Planning Application: 21/04166/F

Proposal: Permission is sought to re-position and amend the structure of the previously allowed 3 bedroom building

Location: The Pheasant Pluckers Inn, Burdrop, OX15 5RQ

Sibford Gower Parish Council **OBJECTS** to this application

SKETCHED VIEW FROM STREET THROUGH BURDROP

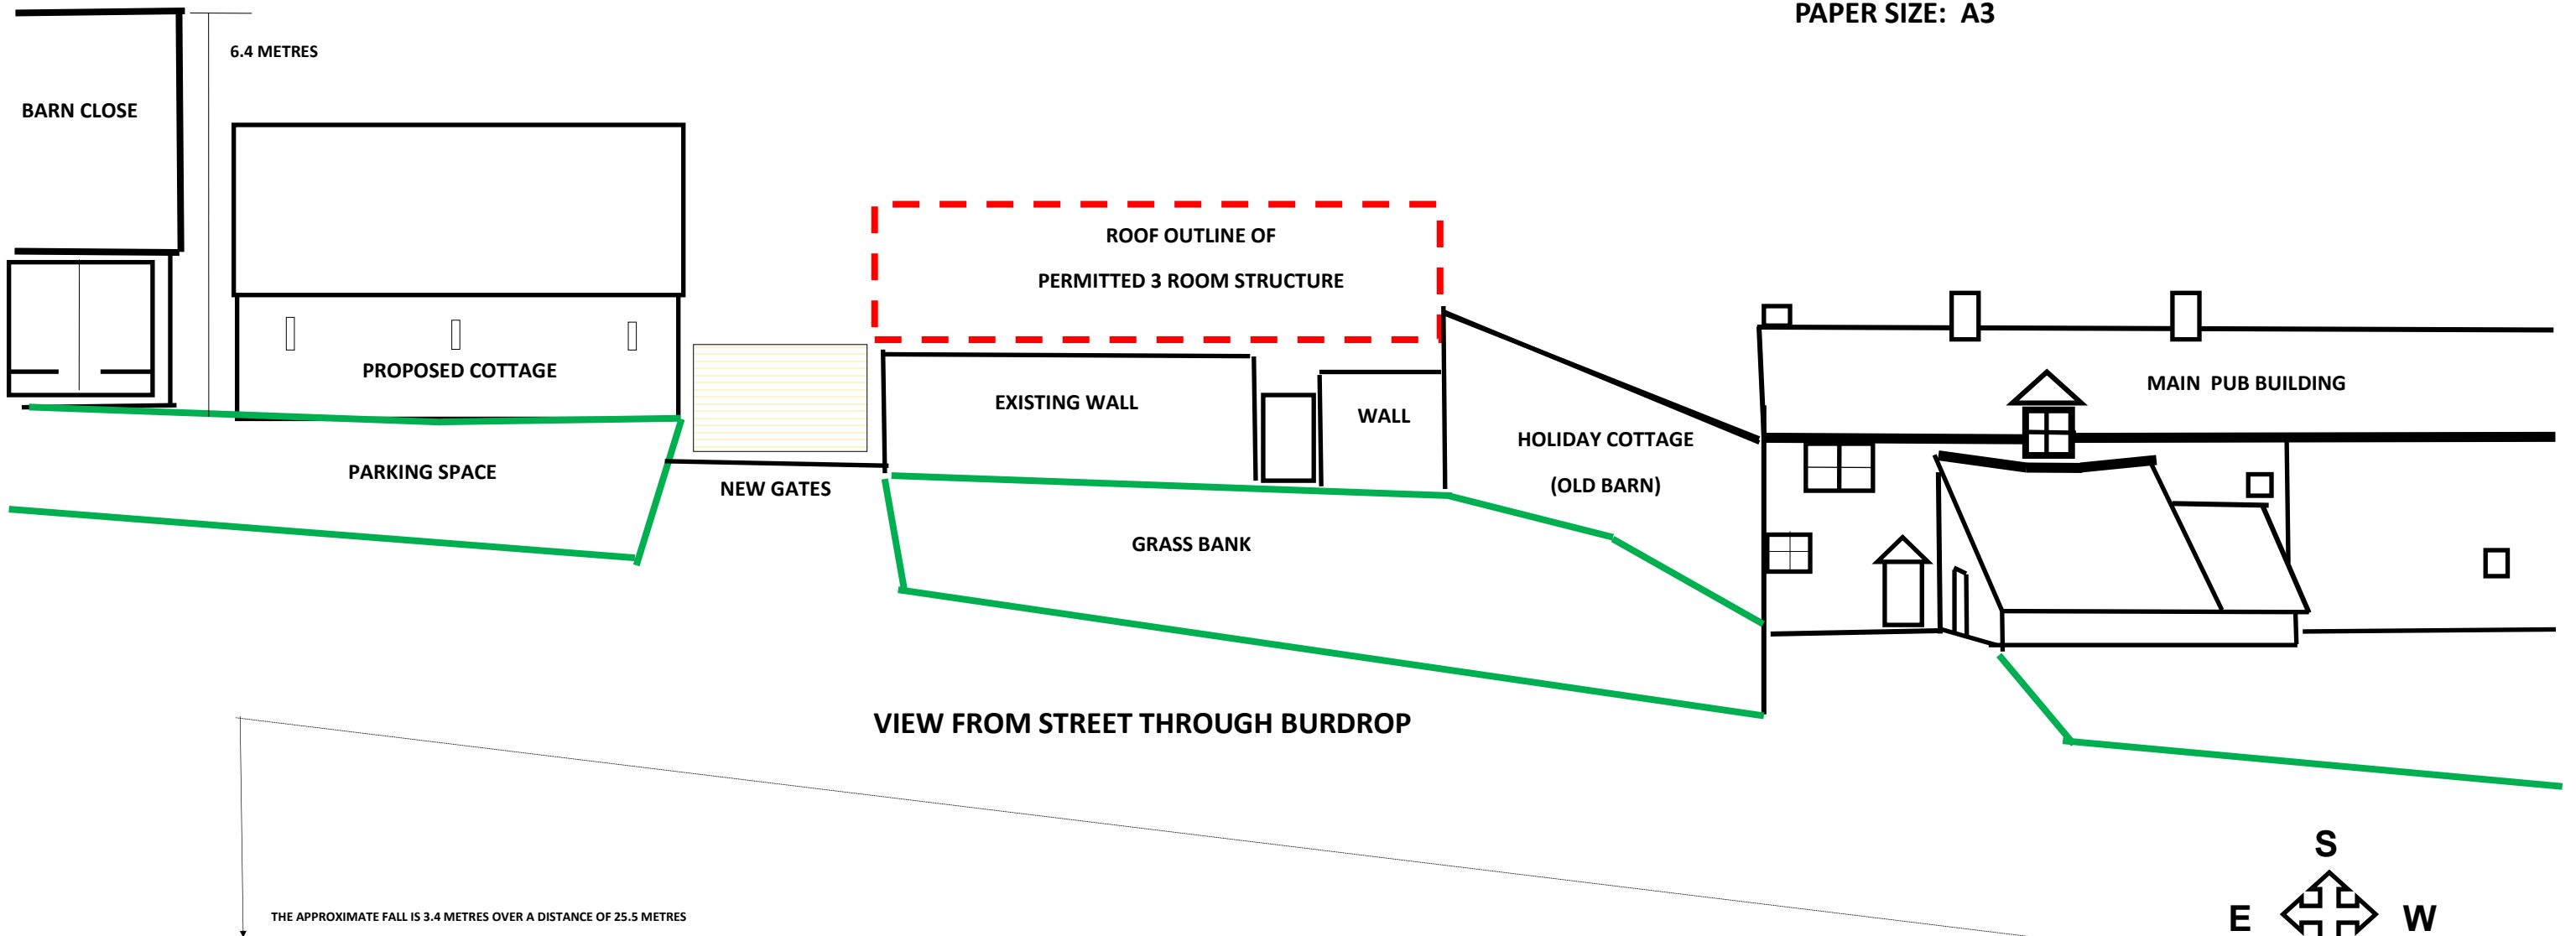
**Size and Scale** – the proposed building has a significantly larger footprint and height, comprising 3 bedrooms, together with kitchen, utility & boots, bathroom and sitting room. This would appear to constitute an entirely new building, identified by the applicant as *the Proposed Cottage*" (p4), rather than an Amendment (p5).

**Design** – the proposed design does not appropriately reflect the photographic evidence provided to support the relocation and is not complementary to this location, thereby having a negative impact on the identified street scene in this sensitive conservation area

**Materials** – the photographic evidence clearly identifies local stone and thatch, which has been retained for the existing neighbouring barn. A similar use of materials would complement the adjacent Grade 2 listed building, generating a positive impact on the street scene in this sensitive conservation area. No specific details are included for doors, windows, rainwater goods
